**ENGINEERING REVIEW COMMENTS IN
BLUE BOXES WITH BLUE TEXT**

**Eastonville Road – Londonderry Dr. to Rex Rd.
Segment 2 Improvements
Stationing 47+00.00 – 79+31.62**

Final Drainage Report

CDR2321

SHEET DRN 1  
 PROPOSED CONDITIONS - DRAINAGE MAP

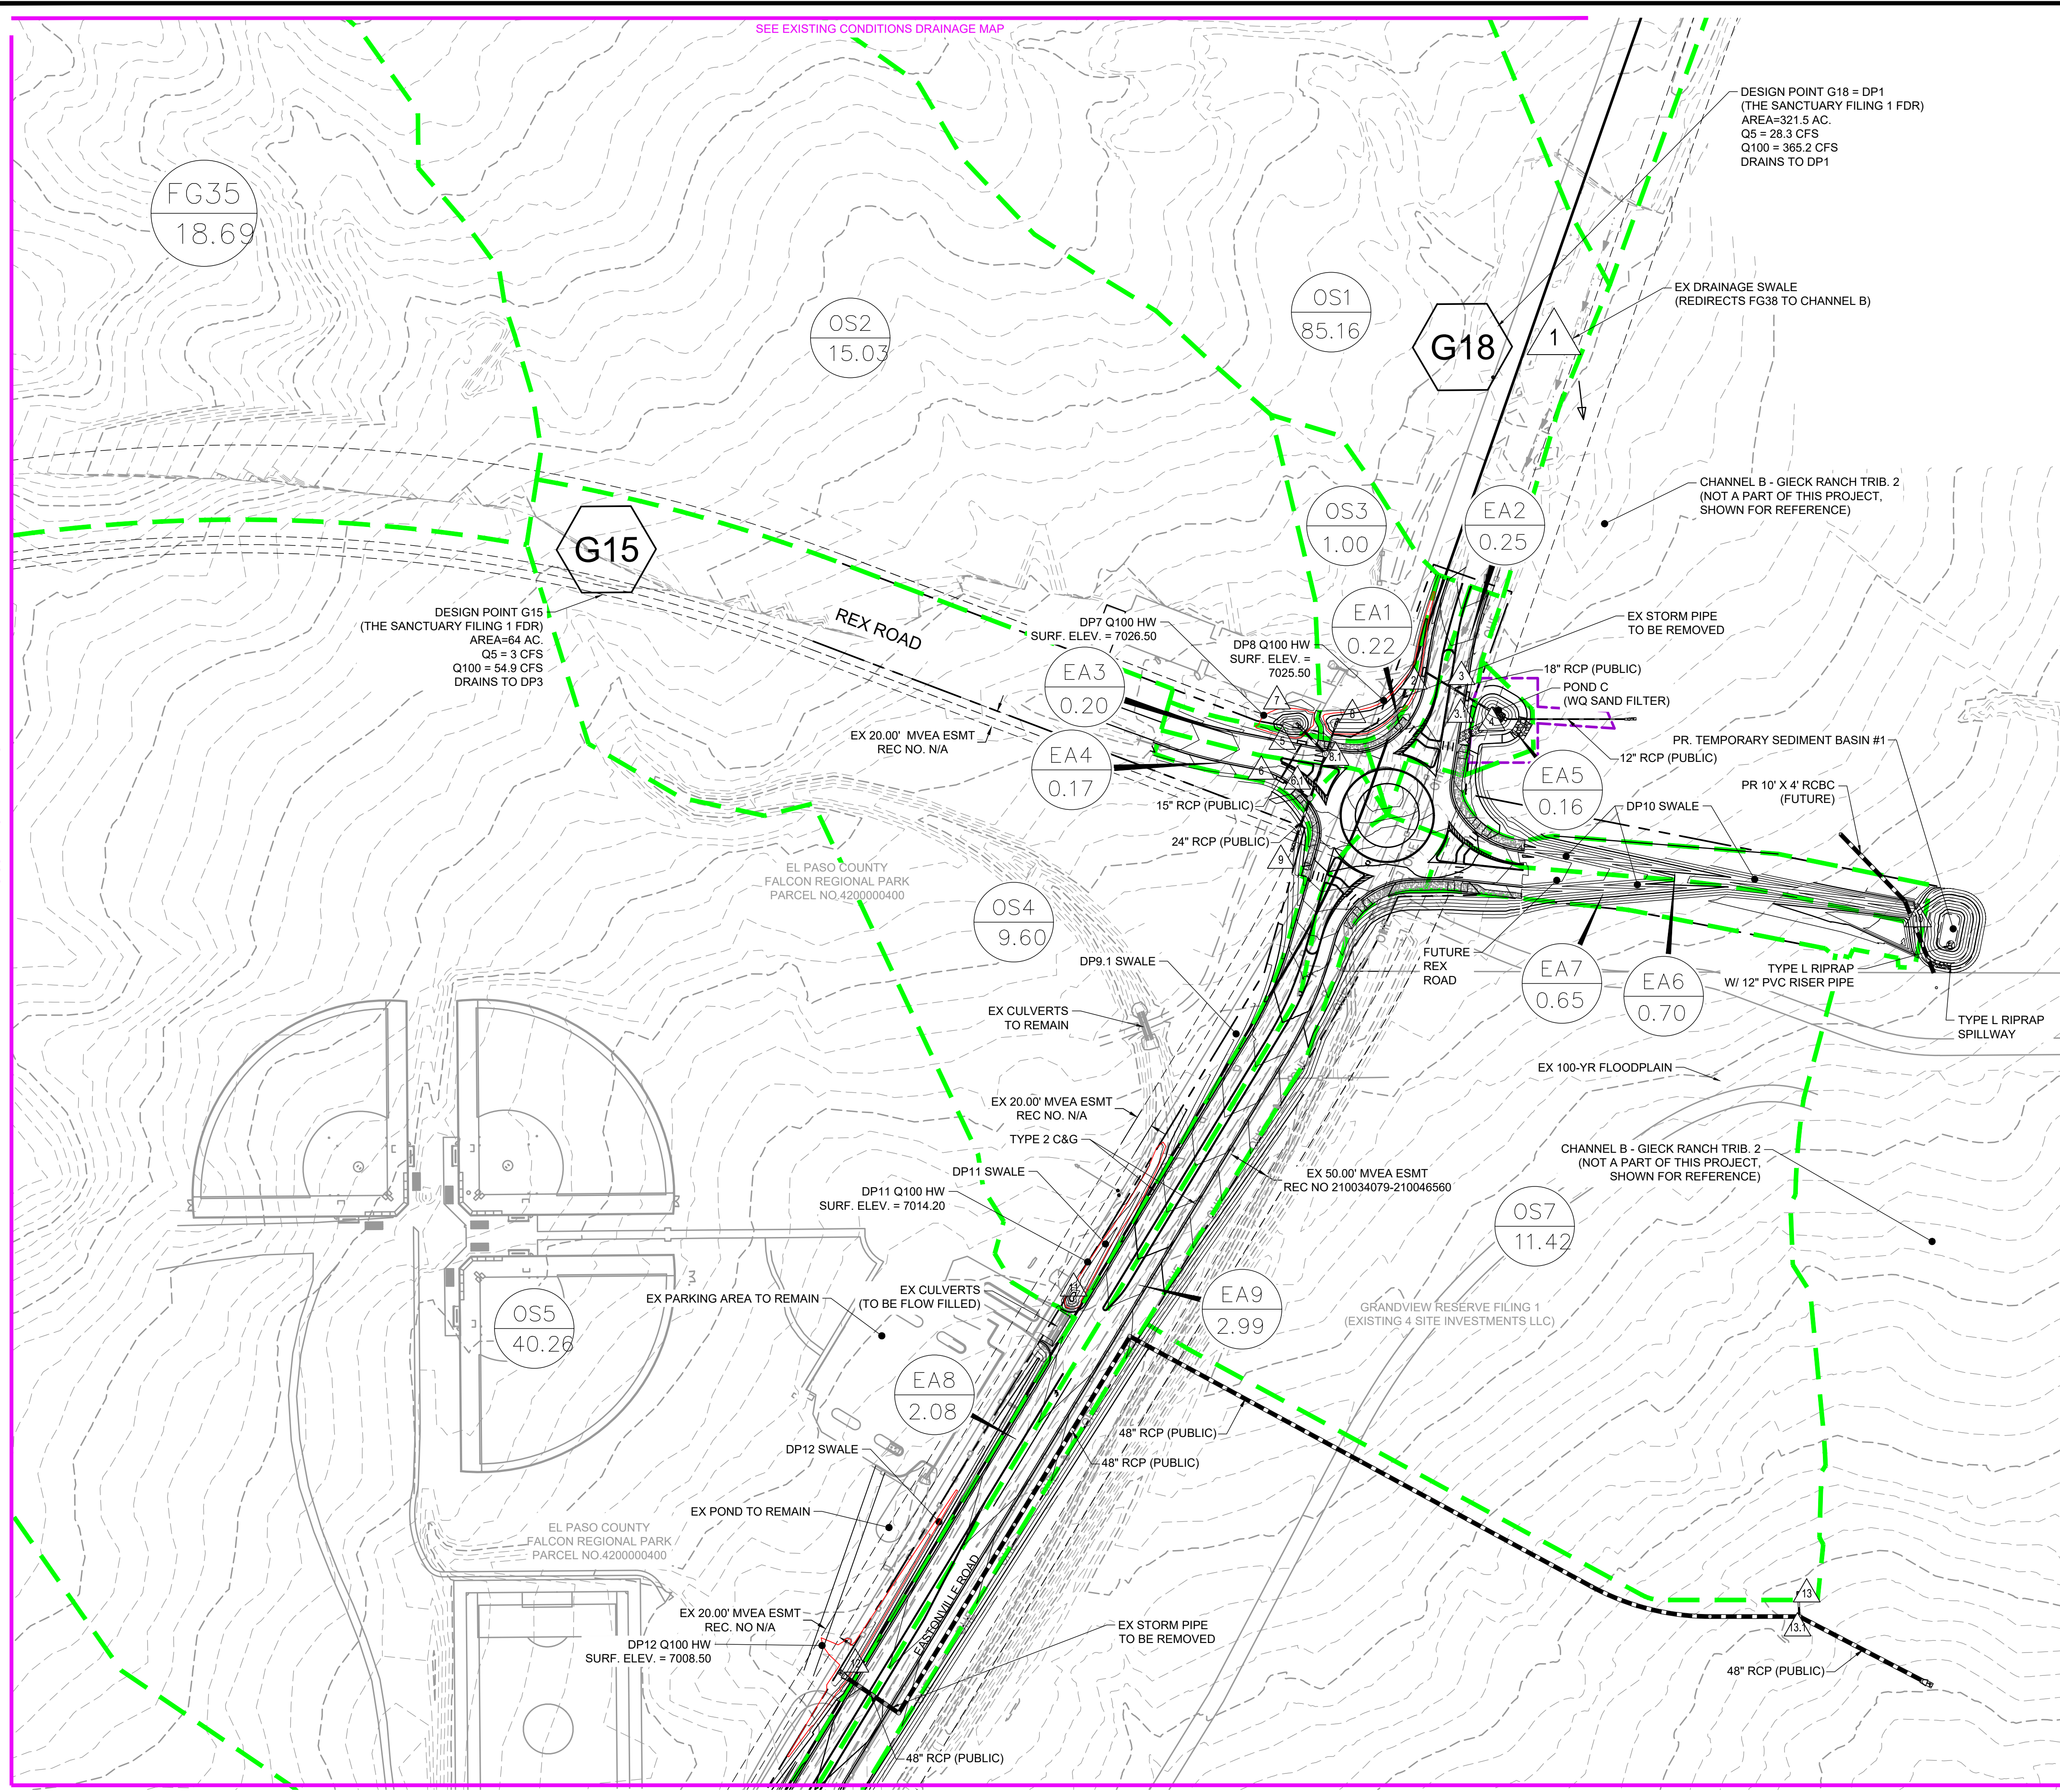
Unresolved:
DP6.1? There is no DP9.1 shown on map or listed in hydrology spreadsheet

Unresolved:
Verify all basin flows with hydrology spreadsheet. Include all basins in spreadsheet and summary table on maps
